## **Waterfront Construction, Inc.**

### **Rosen, Doug - Pier Mercer Island**

#### **SHL21-002 and SEP21-002**

#### **WCI Response to MI Comments dated 1/28/21**

PROPOSED DETAIL VIEW
SCALE: 1/16"=1'

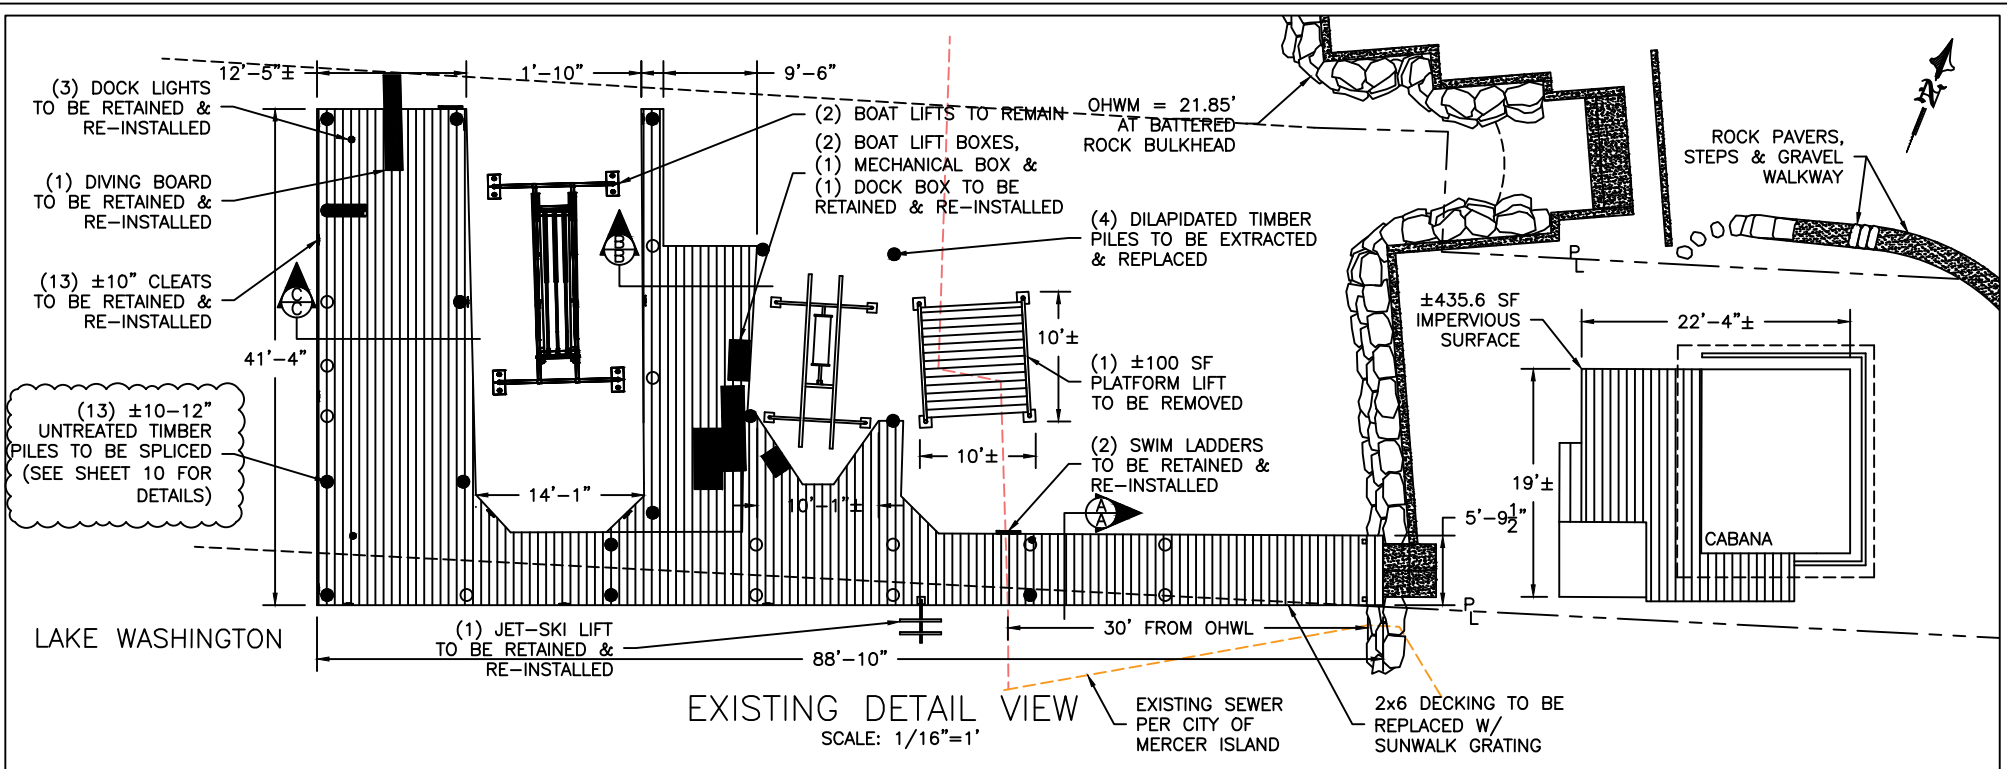
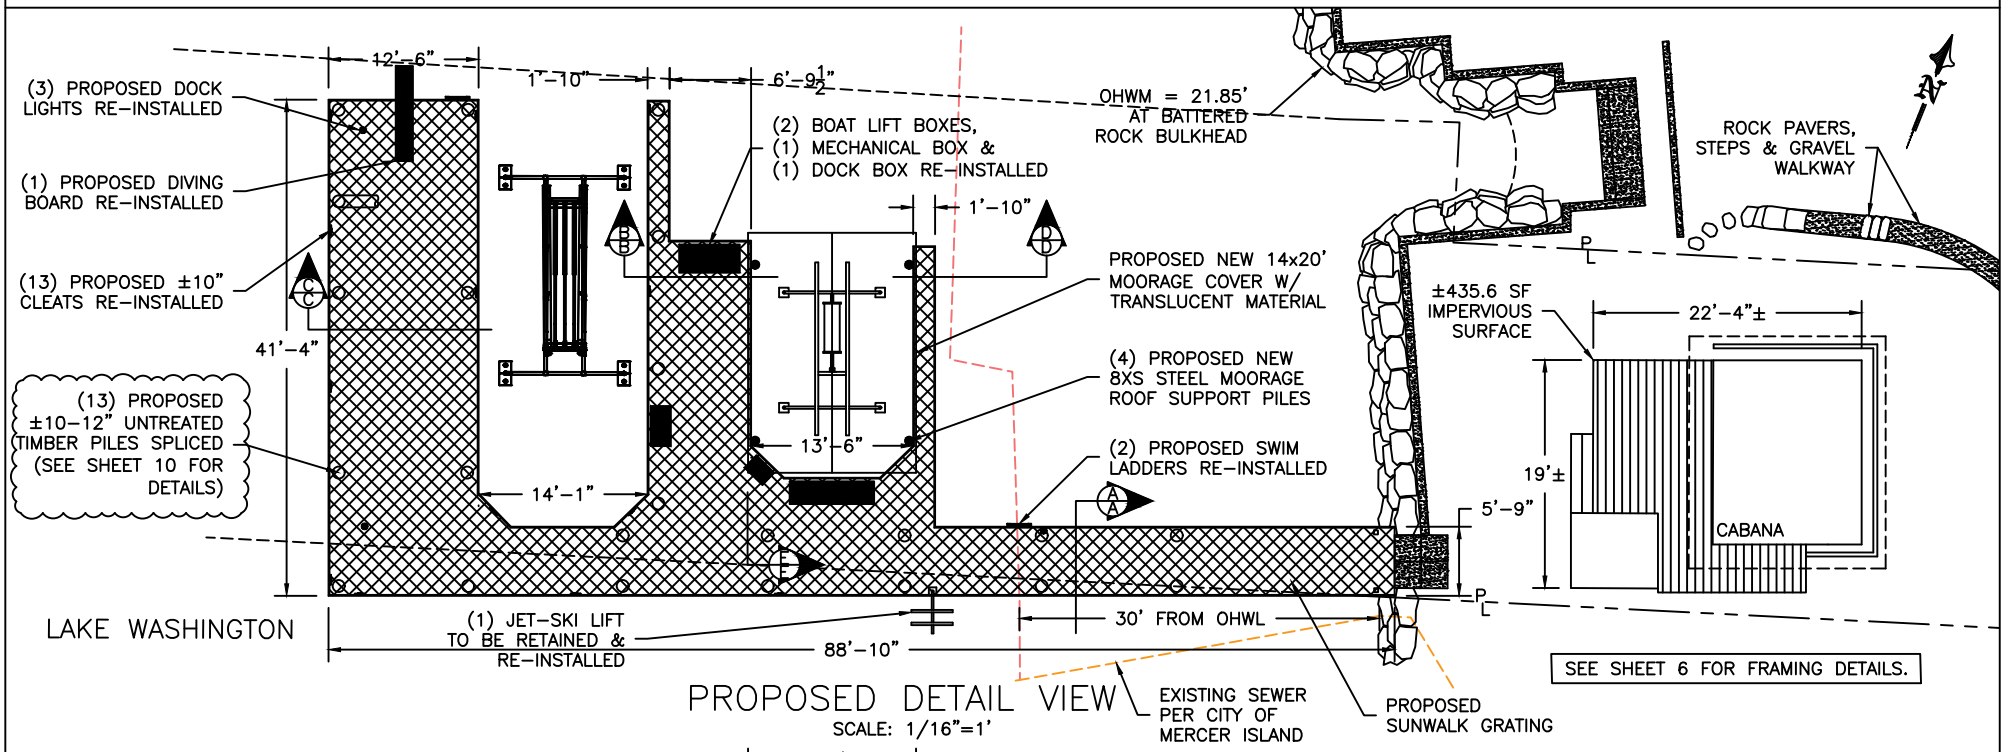
- Please state how the proposal is exempt from a Shoreline Substantial Development Permit per WAC 173-27-040(2)(b) normal maintenance and repair. The footprint of the dock is being expanded in one area – refer to Attachment A. The replacement or development must be “comparable to the original structure or development including but not limited to size, shape, configuration, location and external appearance...” This expansion does not seem to meet the exemption under (2)(b). Please apply for a Shoreline Substantial Development Permit or remove the expansion from the scope of work.

**WCI response:** Damaged portion of the existing finger pier has been removed to prevent materials breaking free from the pier structure and becoming dangerous floating debris. Finger pier to be restored as part of the current permit review. The finger is clearly visible in previous aerial photos and older permit drawings (which are available upon request). Page 4 of the plan set has been revised with a graphic to represent the finger pier and the square footage has been corrected.

Proposed work does not increase the size, shape, configuration, location and/or external appearance and complies with the above requirements for normal maintenance and repairs.
